Phone: 0300 123 6780
Email: developeras@lancashire.gov.uk
Your ref: 3/2026/0601
Our ref: 3/2026/0601/HDC/KW
Date: 09 October 2026

Location: Unit 1 The Old Co-Op Building Henthorn Road Clitheroe BB7 2LD
Proposal: Change of use of Unit 1 to a mixed-use commercial premises comprising a small-scale ironing and garment care business and a community health and wellbeing studio.
Grid Ref: 373721 441454

Summary

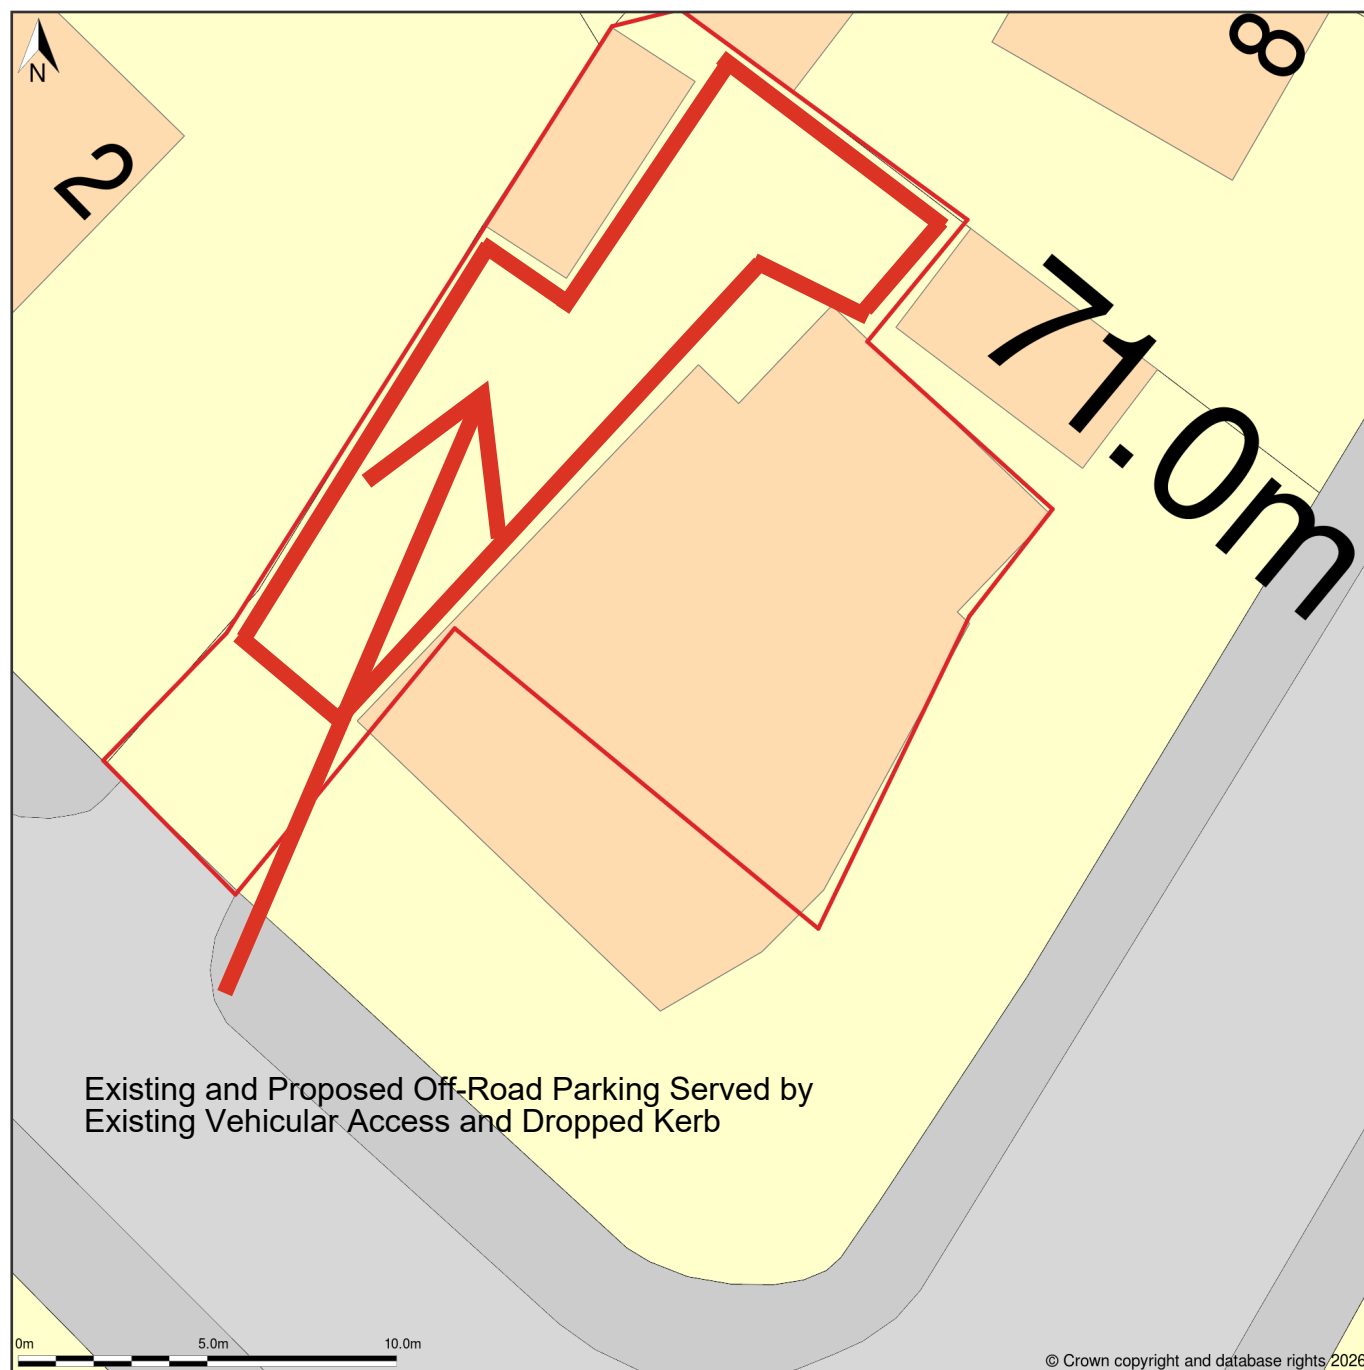
The LHA have reviewed drawing titled existing and proposed off road parking and note that no parking bays or turning area has been shown within the plan. The LHA has undertaken an assessment of the area and given the internal space available, it is unlikely to provide parking for 4 cars without restricting movement to enter and leave independently; however, the area should be retained as a service area to ensure servicing and deliveries for both the proposed commercial units do not take place from the adjacent highway network.

1. The car parking area shall thereafter be always kept free of obstruction and available for servicing and deliveries at all times.
Reason: To allow for the effective use of the parking areas.
2. Prior to first occupation, a separate secure cycle storage facility, suitable for four bicycles shall be provided within the site.
Reason: to promote sustainable transport as a travel option, encourage healthy communities and reduce carbon emissions.
